AENC-NG-CNS-REP-0326

Norwich to Tilbury

**Document: 8.4.7 Applicant's Comments on any Further Information
or Submissions Received by Deadline 1**

Planning Inspectorate Reference: EN020027

COPYRIGHT: NOT TO BE REPRODUCED WITHOUT THE WRITTEN PERMISSION OF NATIONAL GRID ELECTRICITY TRANSMISSION Plc

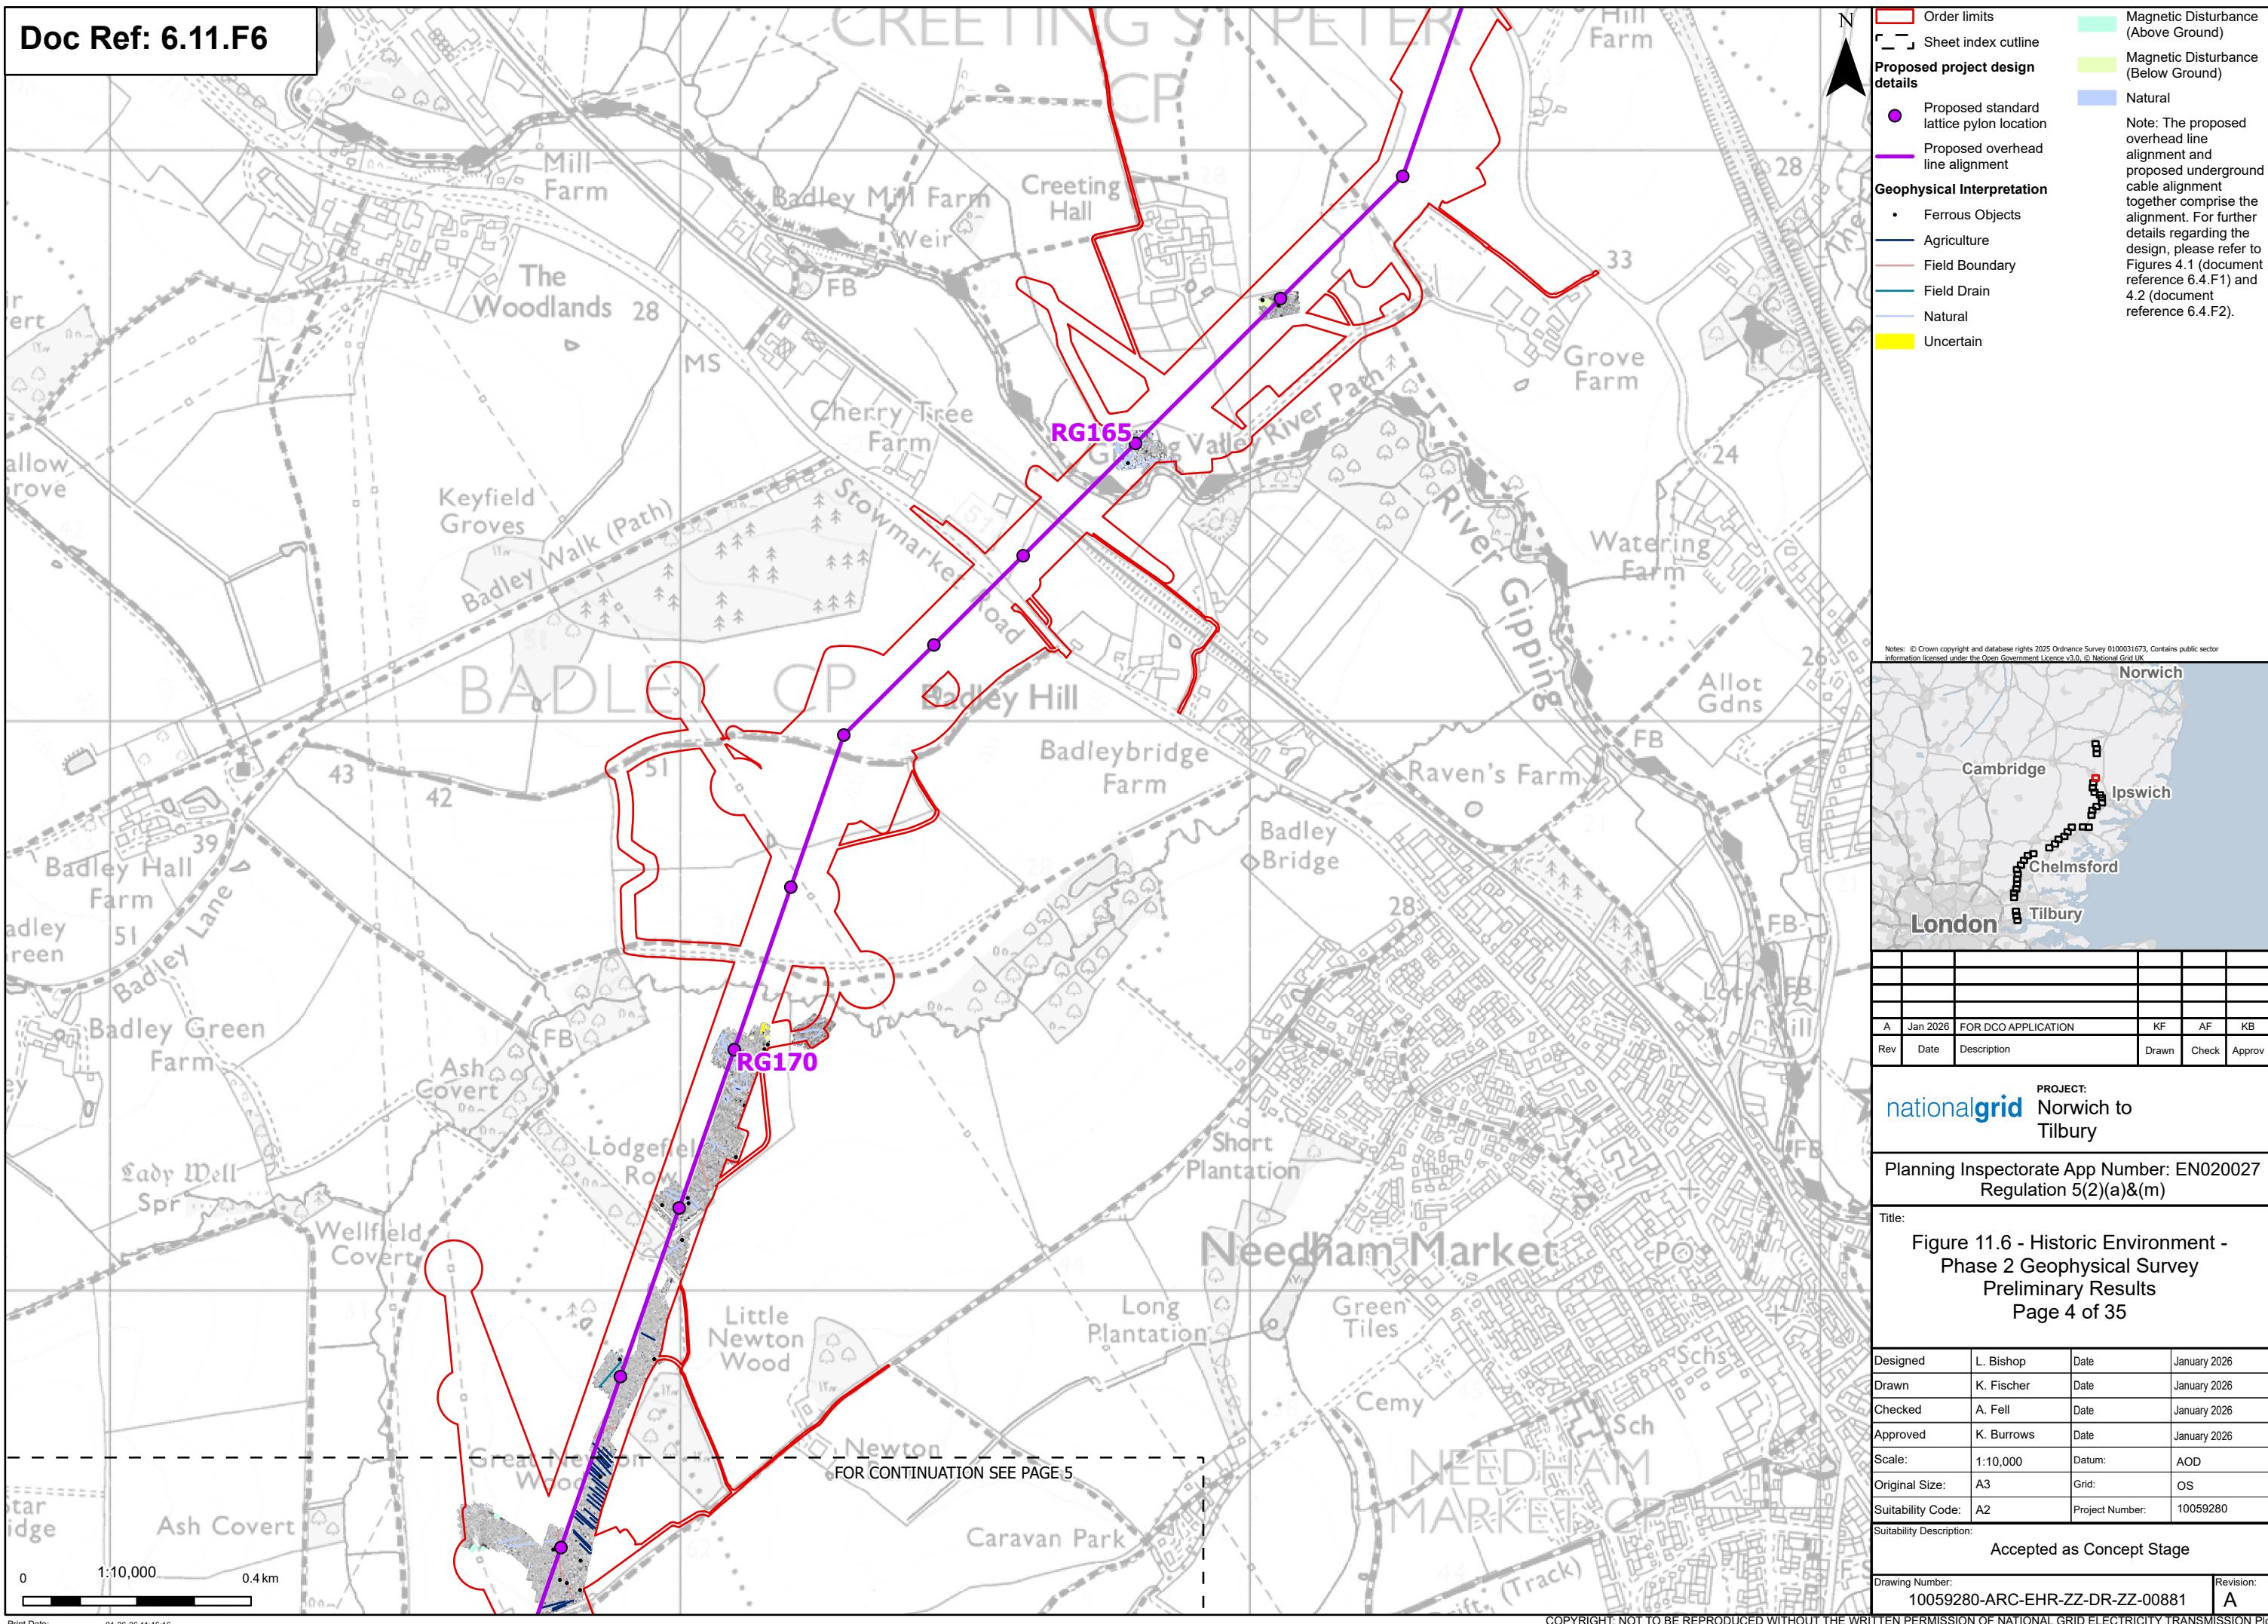
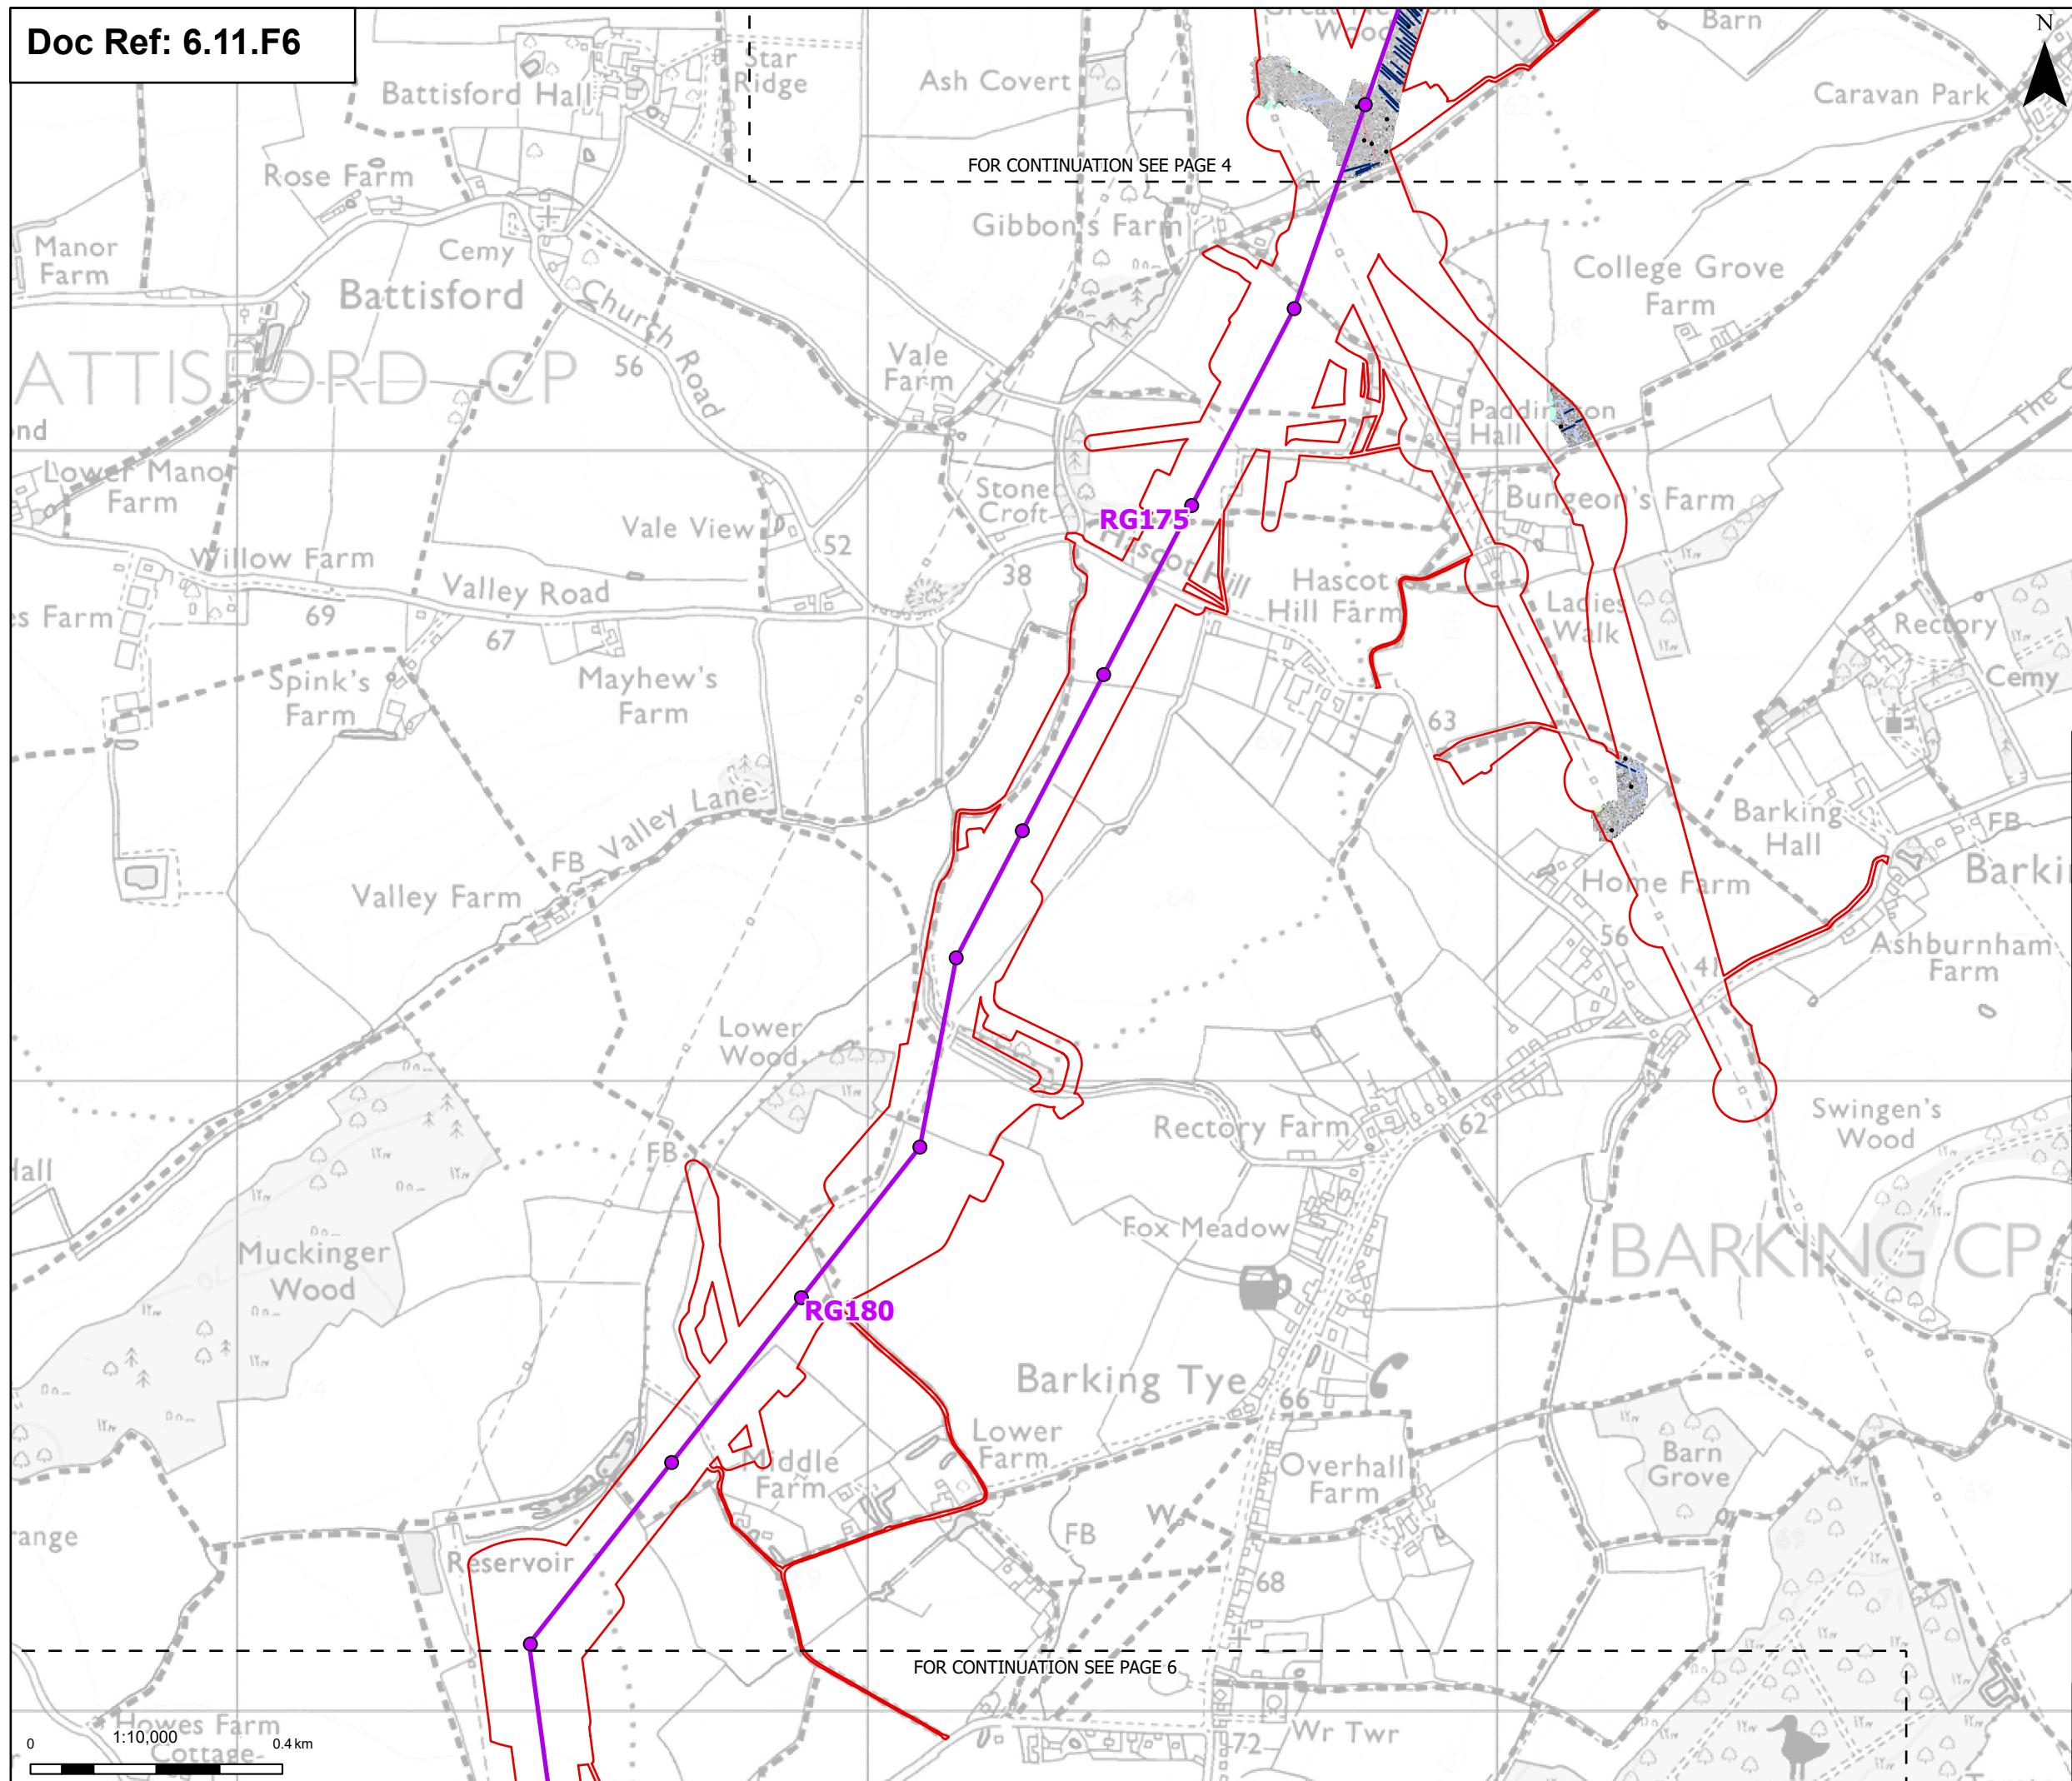
5.27-5.28	<p>5.27 In the Ardleigh PC Historic Environment submission for the 2024 statutory consultation the inadequacy of geophysical survey techniques on the soils in this area was highlighted, as established in NGET's 2024 "EACN Substation Geophysical Survey Report". The issue was highlighted again in the Ardleigh PC response to the 2025 "Essex 2" targeted consultation where NGET documentation showed that geophysical survey results were still being extensively relied upon for locating infrastructure in this archaeologically sensitive area.</p> <p>5.28 Despite this feedback, it is noted that the area of concern was still treated as a "priority geophysical survey" area, as denoted by the green cross hatching around pylons TB5 to TB8 in the following figure, as opposed to a "priority archaeological trial trenching" area. The image was obtained from page 13 of "Figure 11.4 – Historic Environment – Geophysical Survey and Archaeological Trial Trenching Priority</p>	<p>The Applicant notes Ardleigh Parish Council's comments regarding the limitations of geophysical survey techniques in certain soil conditions. A programme of archaeological evaluation including both geophysical surveys and trial trenching, has been discussed and agreed with Local Planning Authority Archaeological Advisors and Historic England, as set out in the relevant Statements of Common Ground (5.9 Draft Statement of Common Ground [APP-089 to APP-100 and APP-102]). All completed interim and assessment reports for geophysical survey and trial trenching were submitted with the application for development consent in 6.11.A4 Environmental Statement Appendix 11.4 - Geophysical Survey Results Report [APP-212] and 6.11.A5 Environmental Statement Appendix 11.5 - Trial Trenching Results Report [APP-213] along with the reports of geoarchaeological and archaeological monitoring of ground investigation works (6.11.A6 Environmental Statement Appendix 11.6 - Geoarchaeological Monitoring of Ground Investigation Works Report [APP-214]).</p> <p>The archaeological evaluation work (geophysics and trial trenching) has continued since the submission of the application for development consent, continuing the Applicant's commitment to the historic environment potentially affected by the Project. The results of the fieldwork up to the end of December 2025 were submitted to the Planning Inspectorate in January 2026 as 6.11 Environmental Statement Chapter 11 - Historic Environment [AS-068] to</p>

Ref	Matter Raised	Applicant's Response
	Areas", submitted by NGET as part of the DCO application	<p data-bbox="1003 180 2121 475">6.11.F6 Environmental Statement Figure 11.6 - Phase 2 Geophysical Survey Preliminary Results [AS-083], of which the historic environment stakeholders are aware. The Phase 2 stage of the geophysical survey and trial trenching will continue throughout 2026, and all the results of this work will be shared with the Local Planning Authority Archaeological Advisors for approval as discussed at monthly meetings and set out in 7.5 Outline Archaeological Mitigation Strategy and Outline Written Scheme of Investigation [APP-328].</p> <p data-bbox="1003 483 2121 783">During the phase 2 archaeological trial trenching, where geophysical techniques are identified as less effective due to local soil conditions, this will be addressed by supplementing the survey with targeted trial trenching, as agreed with archaeological advisors. As illustrated in 6.11.F4 Environmental Statement Figure 11.4 - Phase 1 and 2 Geophysical Survey Areas and Archaeological Trial Trenching Priority Areas (Final Issue B) [AS-082] the Priority archaeological trial trenching survey is completed in the areas adjacent to pylons TB5 and TB6.</p>
